*Erosion Control Team  
600 East Fourth Street  
Charlotte, N C 28202-2844*

# **Rezoning Petition Review**

**Rezoning Petition #:** 21-125

Rezoning Site Plan

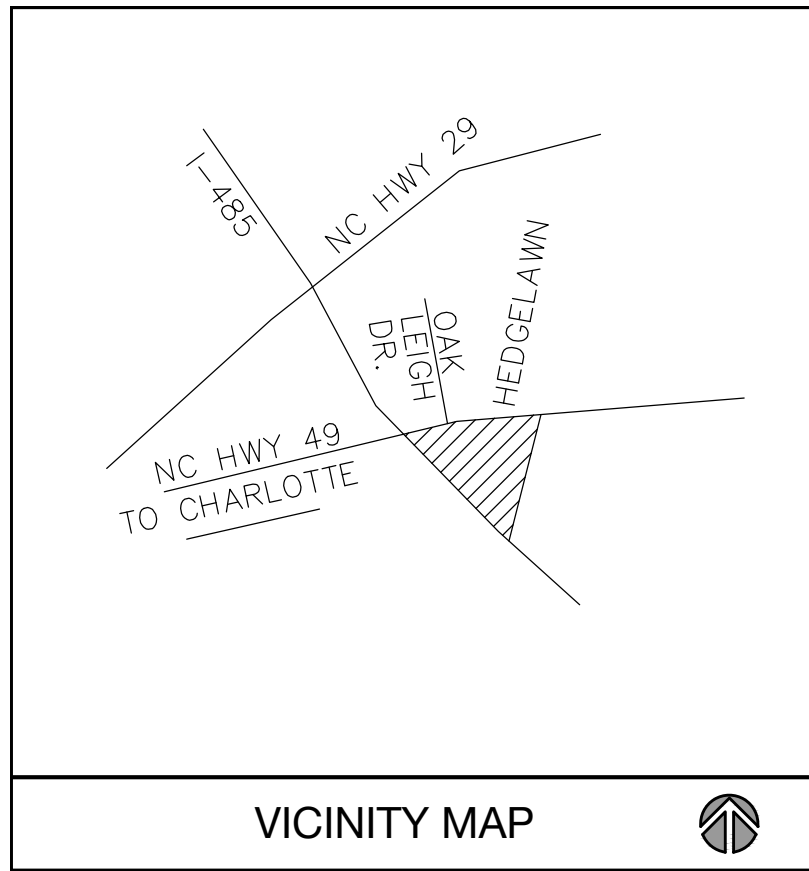
**Drainage/Stormwater Management:** Stream/wetland survey required prior to approval of civil site plan to ensure accurate delineation of top-of-bank/stream buffers/creek path and identification of any protected wetlands that may be on the site.

Avoid stream crossing – access across RR tracks to Hwy 49
